11 July 2022

Our Ref: R/2020/17/B  
Your Ref: SSD-12618001

**Advice on Response to Submissions - 104-116 Regent Street, Redfern - Student Accommodation (SSD-12618001)**

1 Level 1 (Ground)
Floor Plan
1 : 200

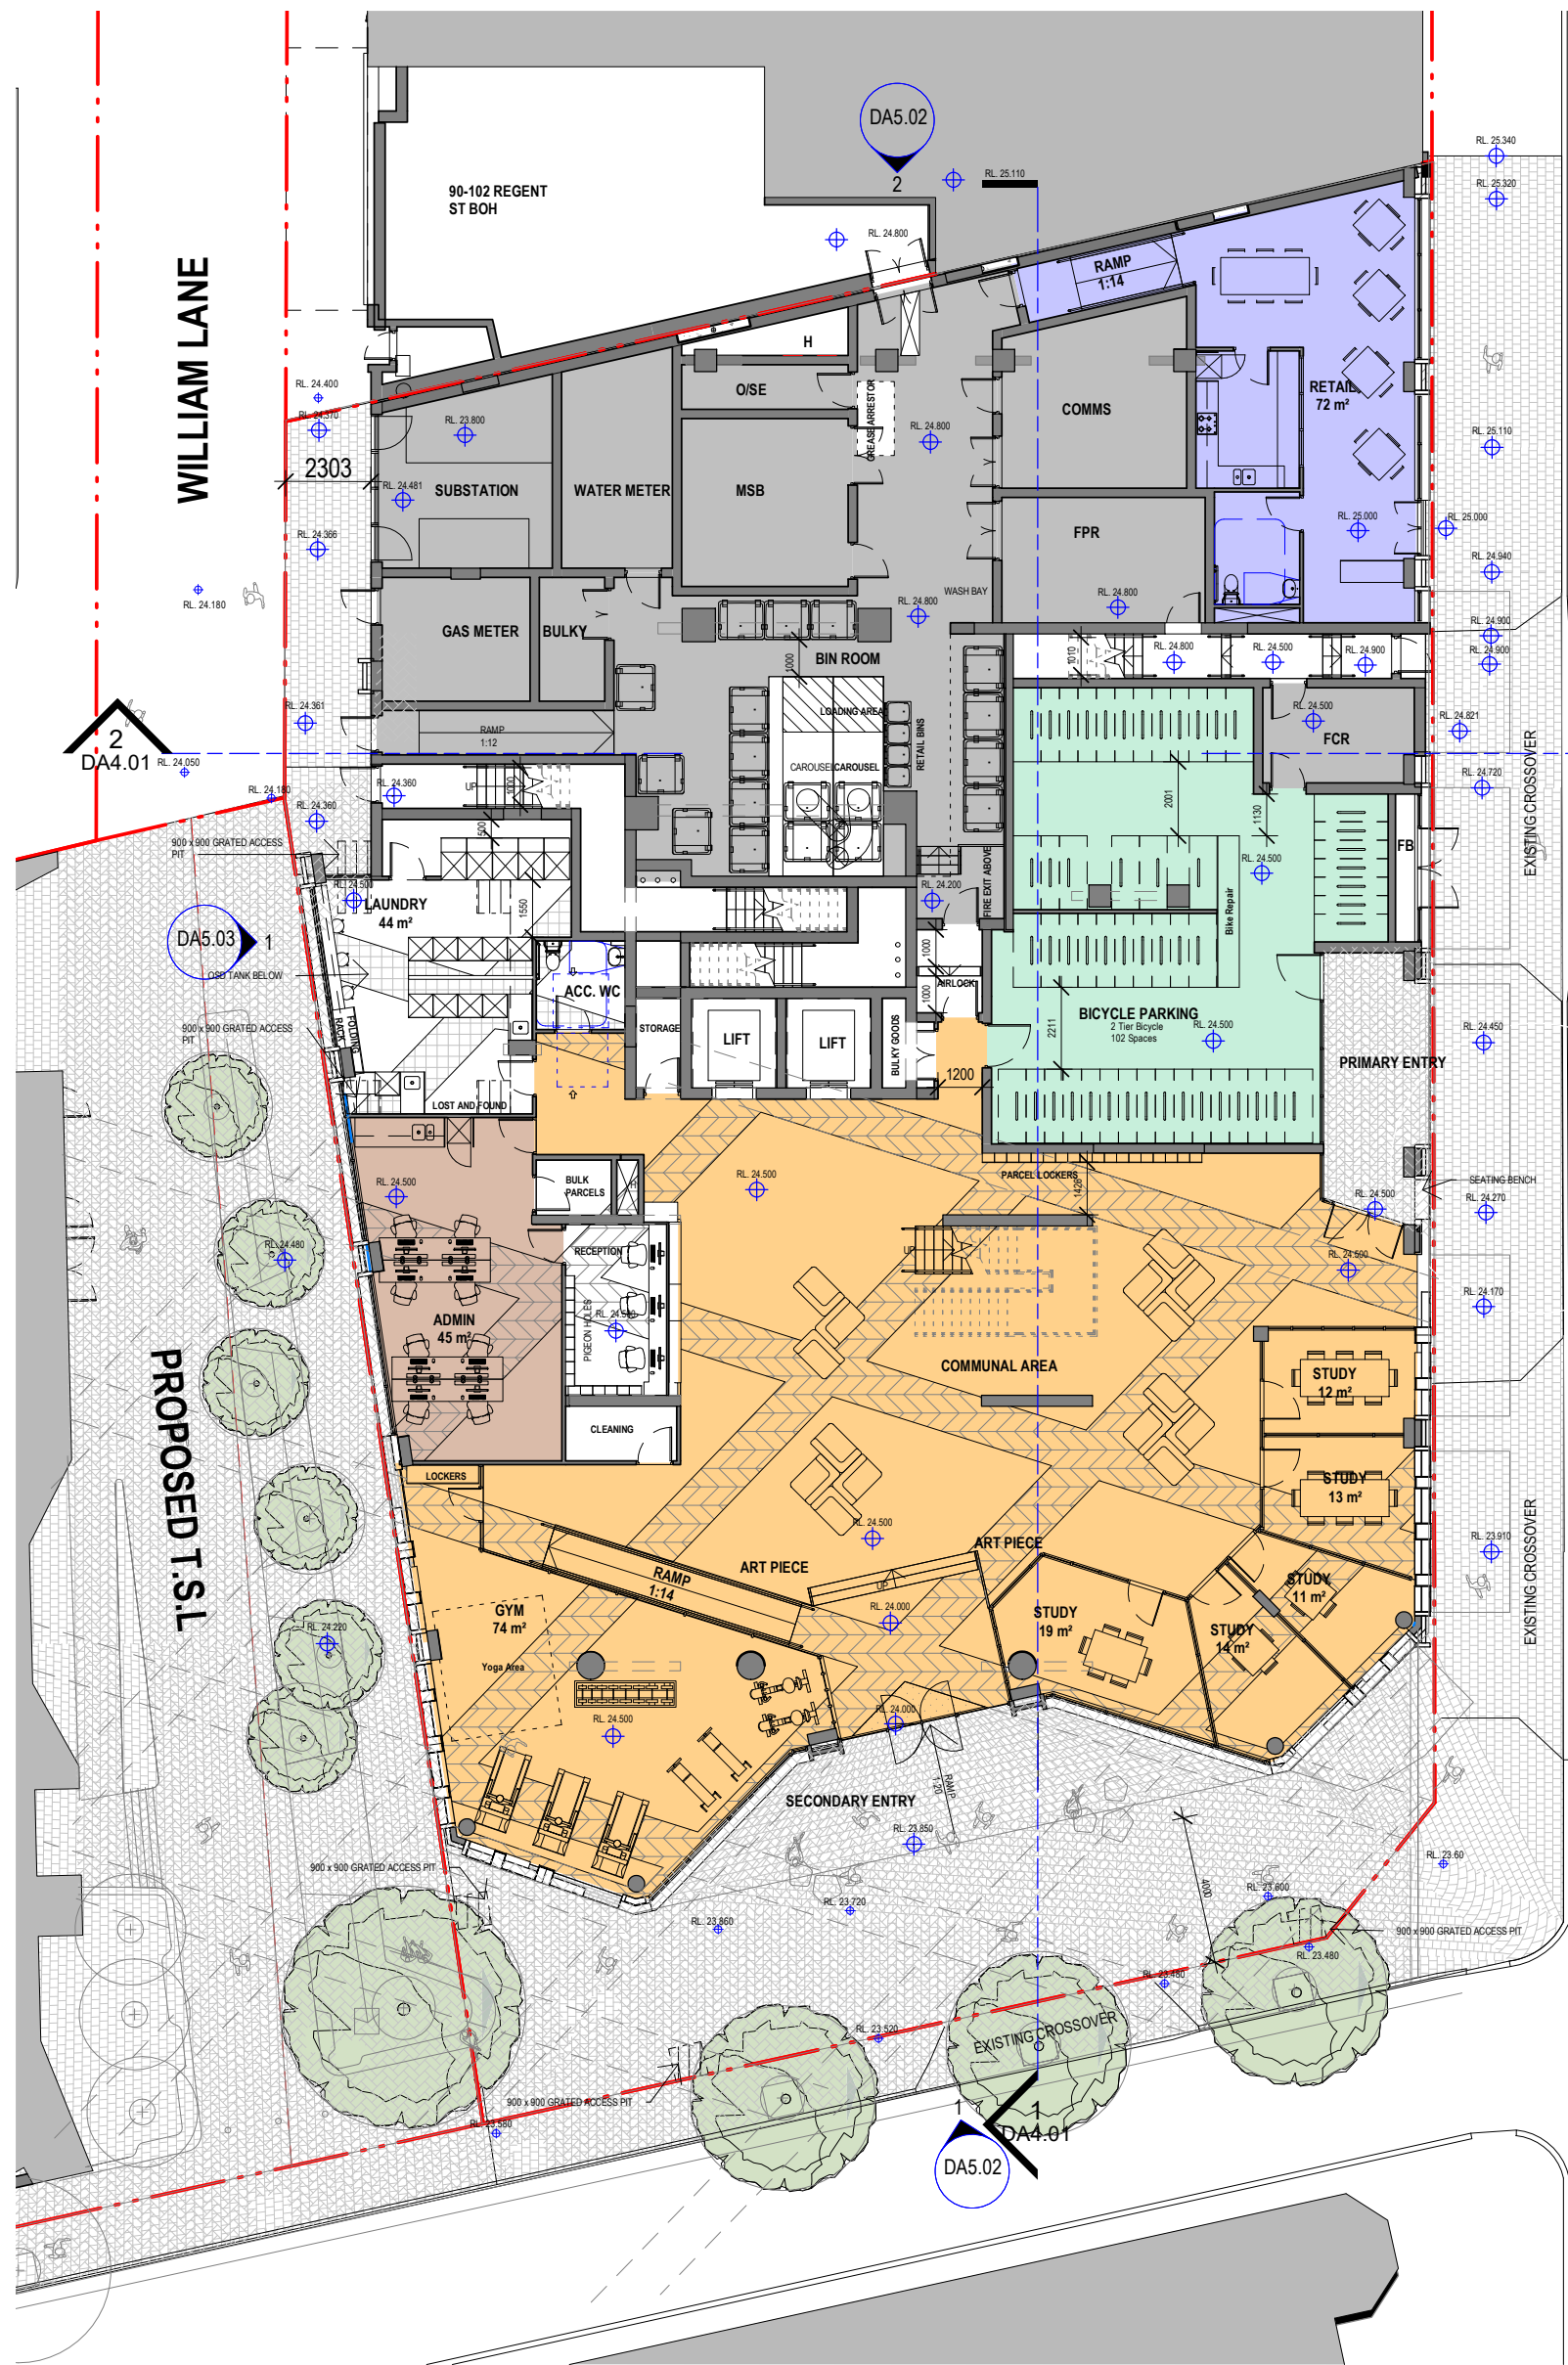
The proposed gym area on the south-western corner of the ground floor is an ideal location for a food and drink premises that could activate Margaret Street along the southern boundary and the pedestrianised William Lane extension on the western boundary (refer to **figure 1**). The provision of a food and drink premises at this location will not only attract residents but also locals and pedestrians and would achieve the objectives of an active frontage, away from the heavy volumes of traffic down Regent Street with its associated air and noise pollution. The food and drink premises would be visible from Regent Street and Margaret Street and could have an internal link to the proposed internal laundry immediately adjacent to the space on the ground floor, providing students with greater amenity and convenience.

Further, the City reiterates previous comments in relation to the 2.8m floor to ceiling heights of the ground floor retail tenancy on Regent Street. This presents as a residential scale and should be increased.

- (a) The floor to ceiling height is to be increased directly behind the facade by increasing the RL of the inaccessible landscape located above the retail tenancy.
- (b) The retail glazing is to be amended to be full height by removing mechanical louvres

DRAWING TITLE
Northern Elevation + Southern
Elevation

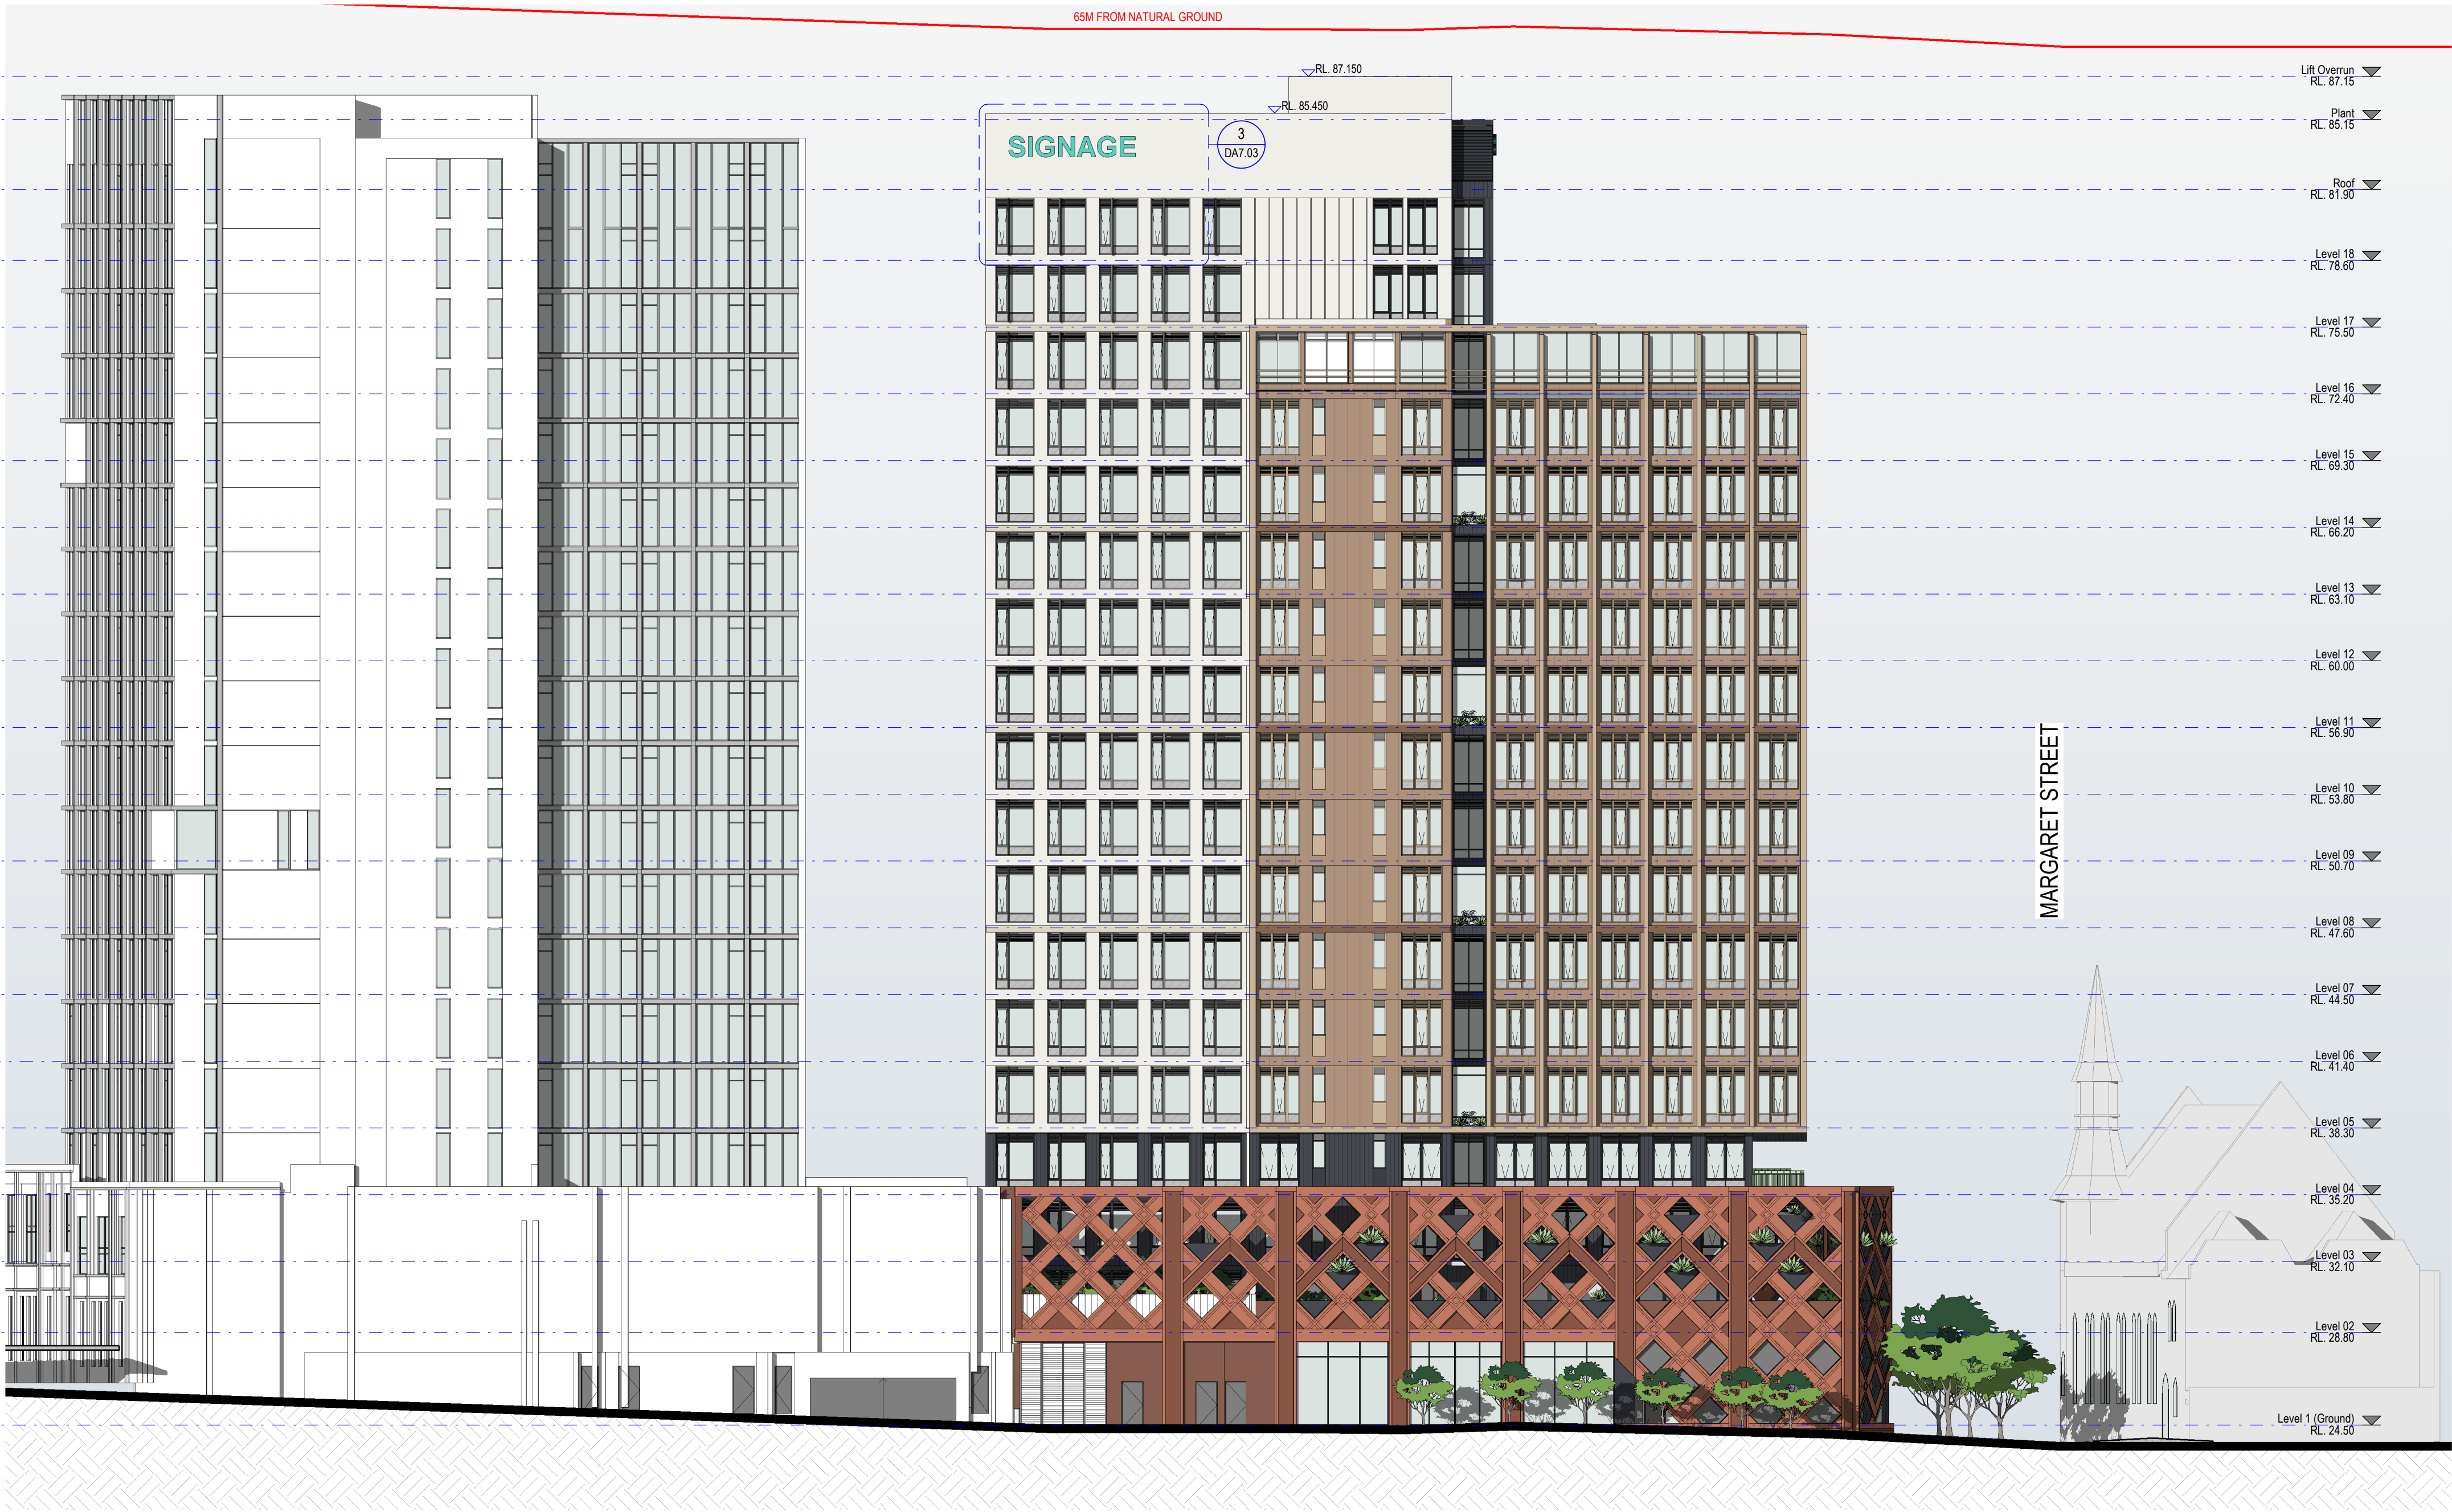
The RTS has sought to address the City's previous concerns regarding the blank building expression on the northern and southern elevations through the provision of reckli form liner patterns to create a textured and modulated façade. Public art is proposed to be designed and integrated in the reckli patterns.

This response can be acceptable to the City if the facade can accommodate sufficiently thick form liner panels to deliver an artwork of depth in the façade. It is strongly suggested that an indigenous artist be engaged to produce any future artwork for the development, particularly with Redfern's strong historical links to Aboriginal people and culture.

3 William Lane Signage
Elevation 1:50

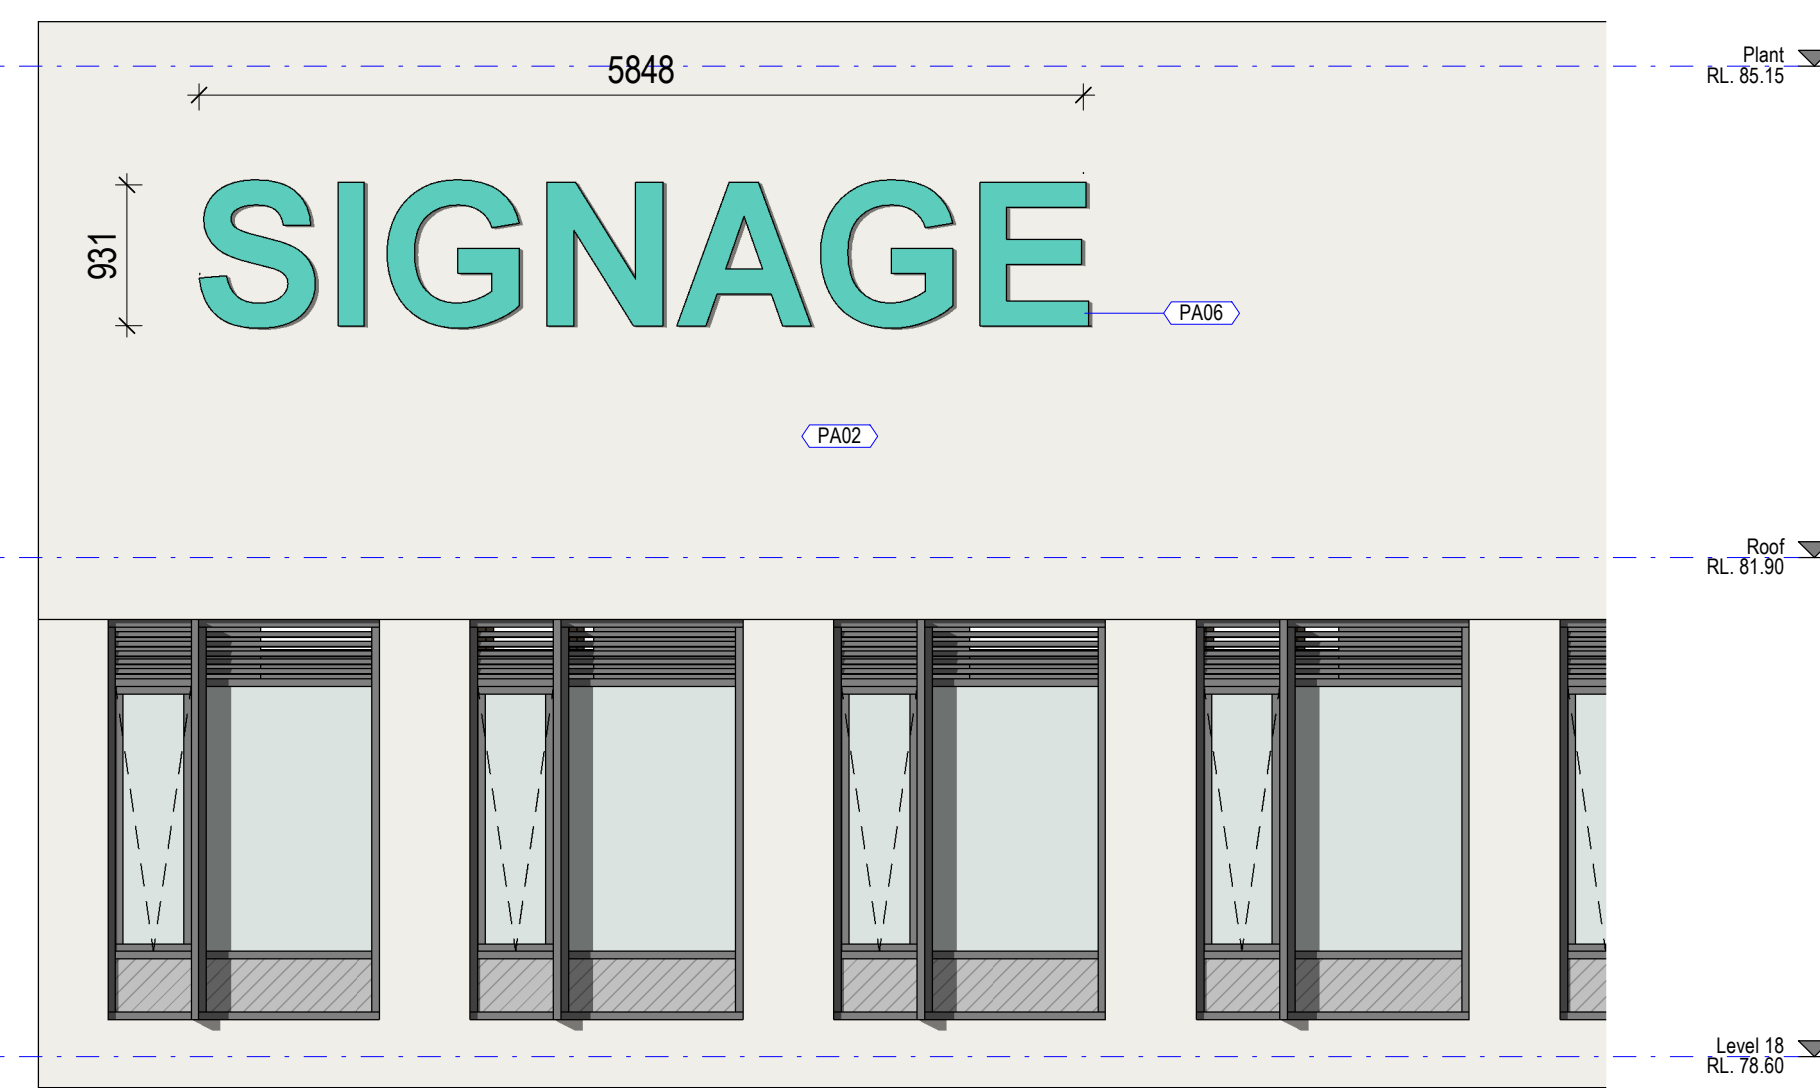
Further, the William Lane podium signage is excessively wide and is not supported. A maximum 300mm width lettering is recommended, with individual lettering pinned on a quality finish wall.
